### EN010103: THE NET ZERO TEESSIDE NATIONALLY SIGNIFICANT INFRASTRUCTURE PROJECT. DEADLINE 4 SUBMISSIONS. LAND IN THE VICINITY OF THE SSI STEEL WORKS SITE, REDCAR, TEESSIDE, TS10 5QW

### **Environment Agency Summary of Representations**

#### **Environment Agency Written Representations**

KEY PLAN
Scale 1:20,000

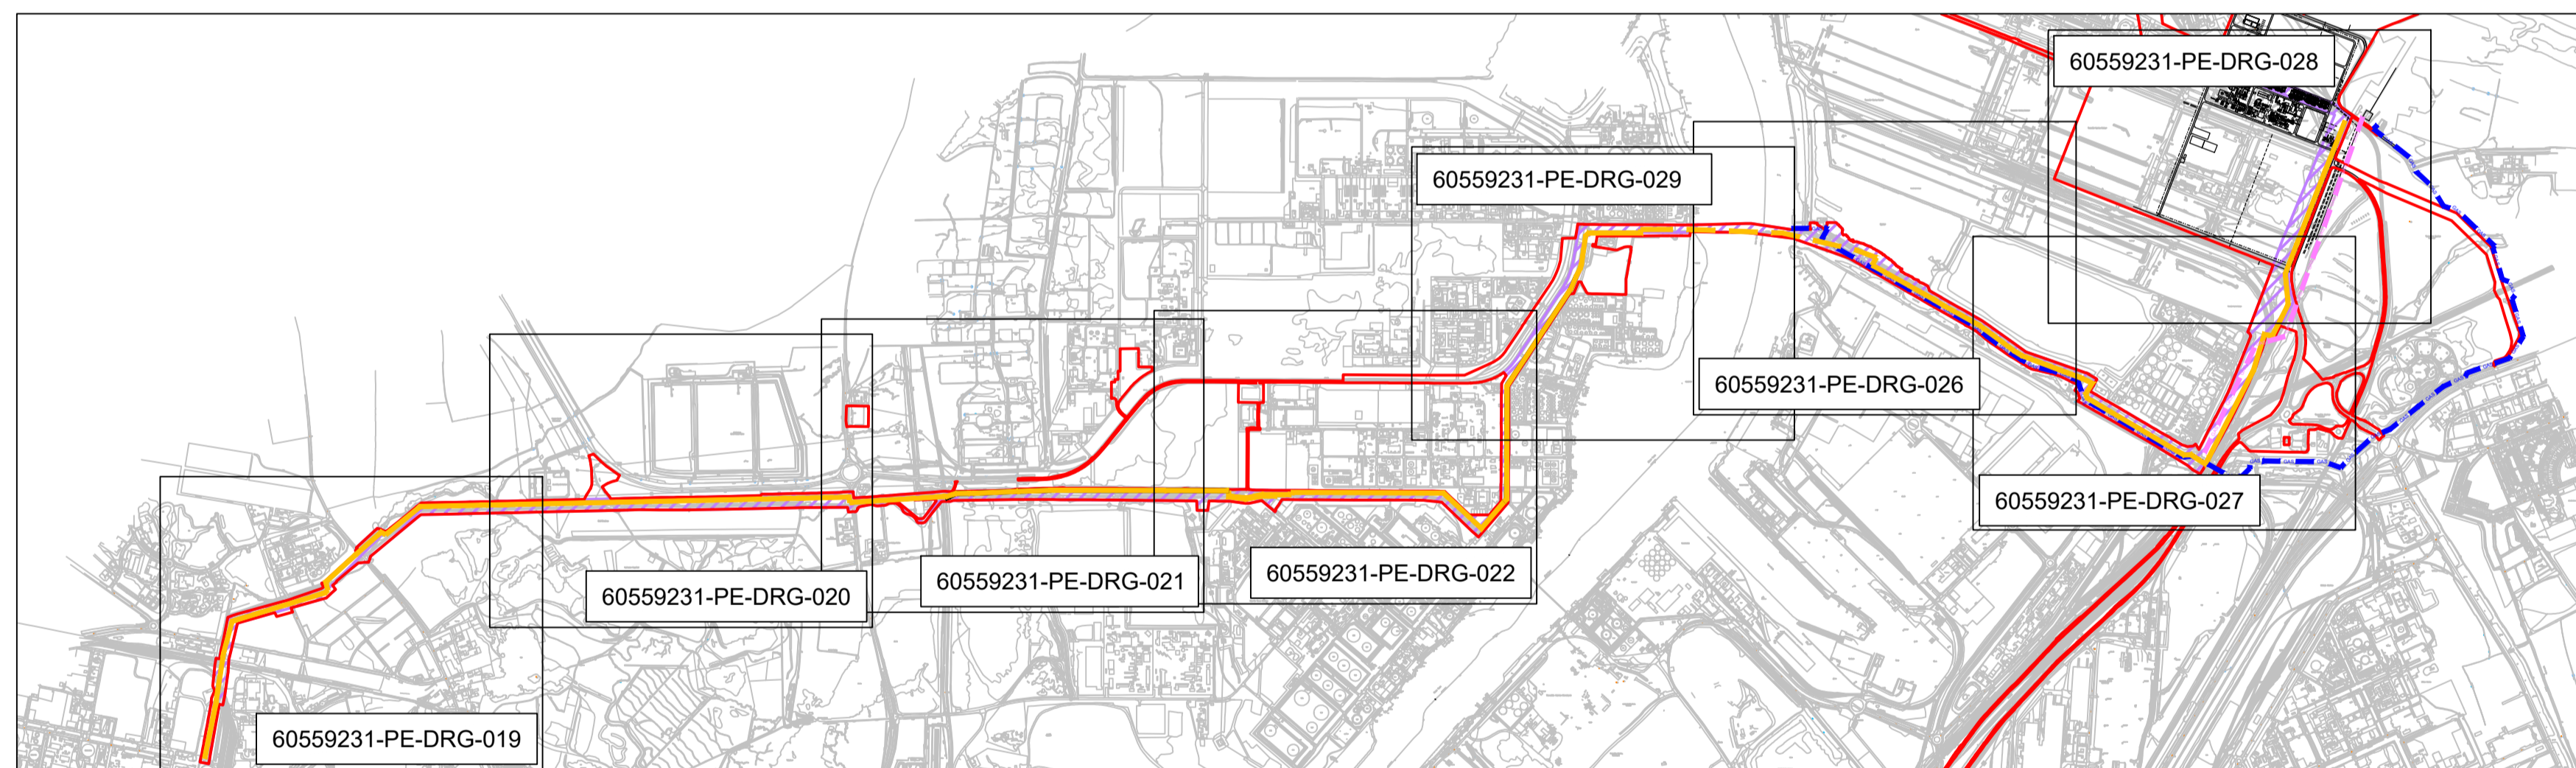
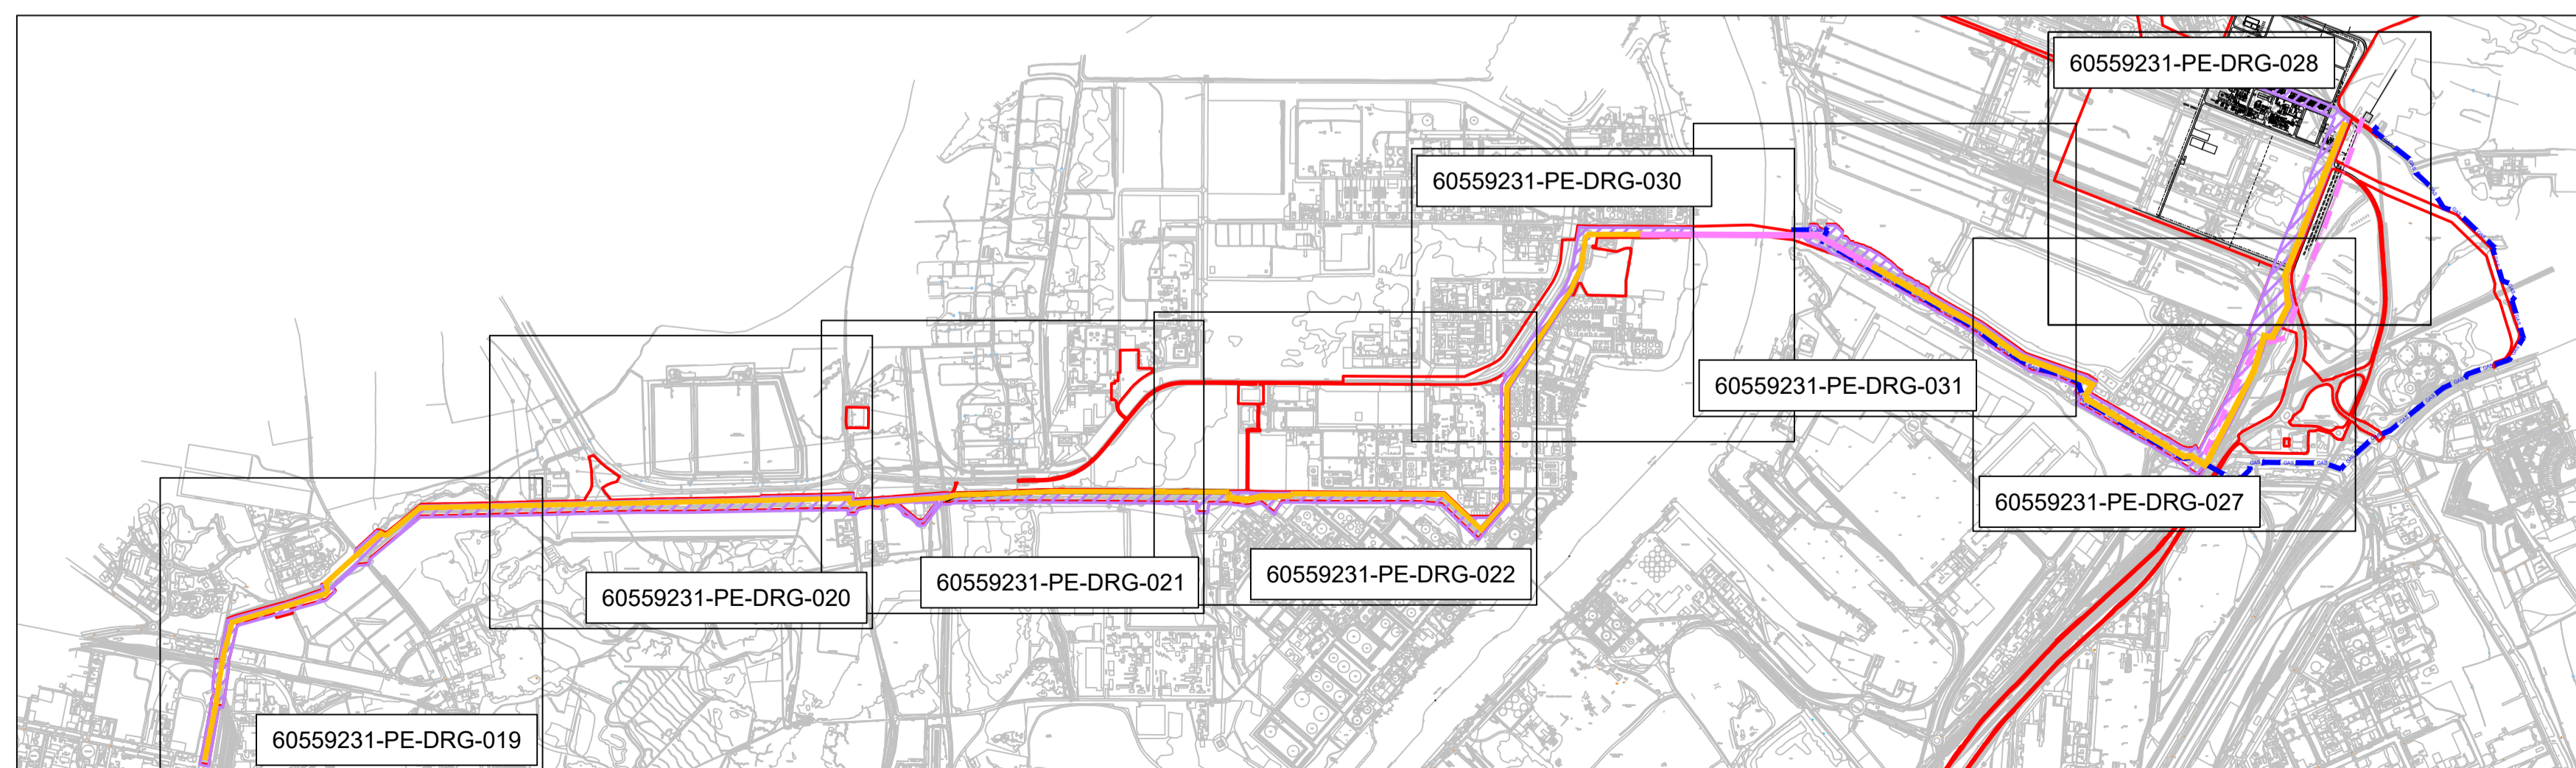
There appears to be no requirement to construct Work No. 6, the carbon dioxide gathering network. Therefore, we are concerned the DCO will allow the construction of a new power station without the additional regional benefit of the wider  $CO_2$  gathering network. Can the Applicant confirm what mechanisms are in place within the DCO to ensure that the  $CO_2$  gathering network will be built? Or could this requirement be amended to state that work on Work No. 6 will start within a set date, possibly 1 year, of the start of Work No.1?

There appears to be no requirement to construct Work No. 6, the carbon dioxide gathering network. Therefore, we are concerned the DCO will allow the construction of a new power station without the additional regional benefit of the wider  $CO_2$  gathering network. Can the applicant confirm what mechanisms are in place within the DCO to ensure that the  $CO_2$  gathering network will be built? Or could this requirement be amended to state that work on Work No.6 will start within a set date, possibly 1 year, of the start of Work No.1?
